Subject: Hydrant condition - Y/33/21/PL Plum Pudding Barn Hoe Lane Flansham PO22 8NS

HYDRANT CONDITION CONSULTATION WITH PLANNING AUTHORITY

Planning Ref: Y/33/21/PL

Description: Conversion of existing barn to 1 No. residential dwelling with associated parking (resubmission following Y/137/20/PL). This site is in CIL Zone 3 & is CIL Liable as new dwelling.

PROPOSED BLOCK PLAN, Sc. 1:500

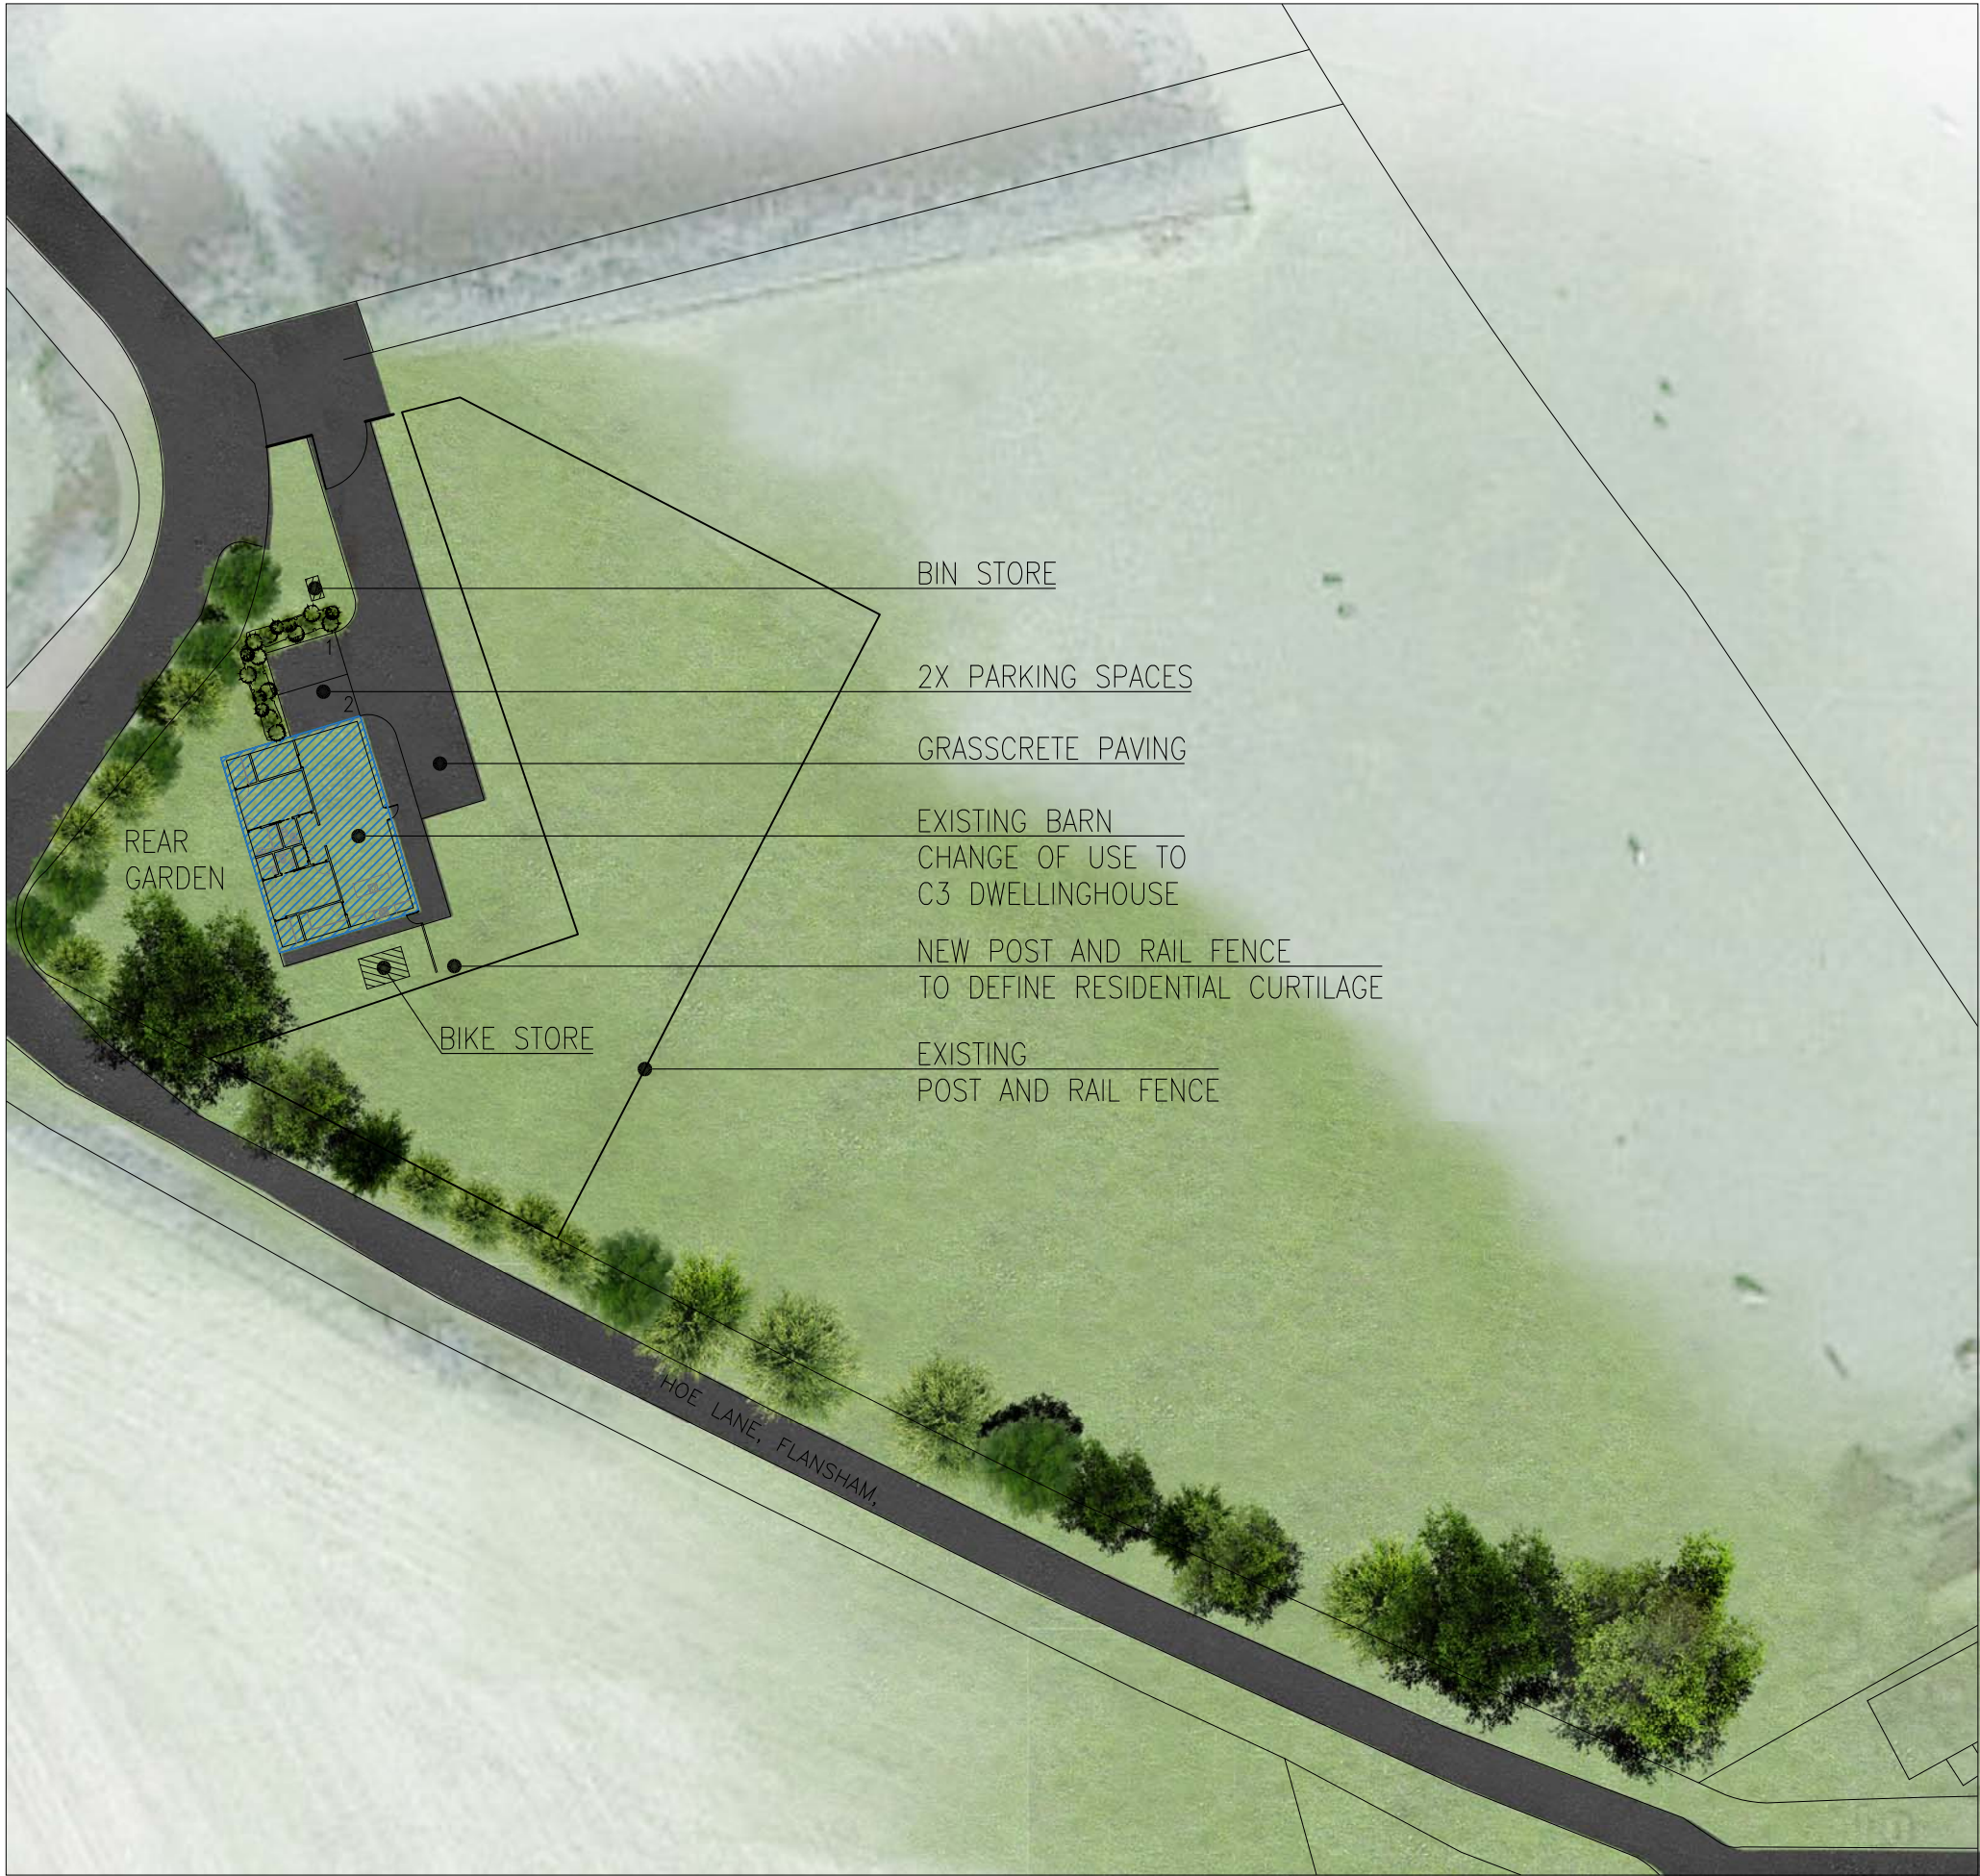
Please find attached a planning condition for application no. Y/33/21/PL for the requirement of an additional fire hydrant. Currently the nearest Hydrant to these proposed properties is 270 metres away. The supply of water for firefighting for a domestic premises should be within 175 metres.

- 1) Prior to the commencement of the development details showing the proposed location of [1] one fire hydrant or stored water supply (in accordance with the West Sussex Fire and Rescue Guidance Notes) shall be submitted to and approved in writing by the Local Planning Authority in consultation with West Sussex County Council's Fire and Rescue Service. These approvals shall not be unreasonably withheld or delayed.
- 2) Prior to the first occupation of any dwelling/unit forming part of the proposed development that they will at their own expense install the fire hydrant in the approved location to BS 750 standards or stored water supply and arrange for their connection to a water supply which is appropriate in terms of both pressure and volume for the purposes of firefighting.
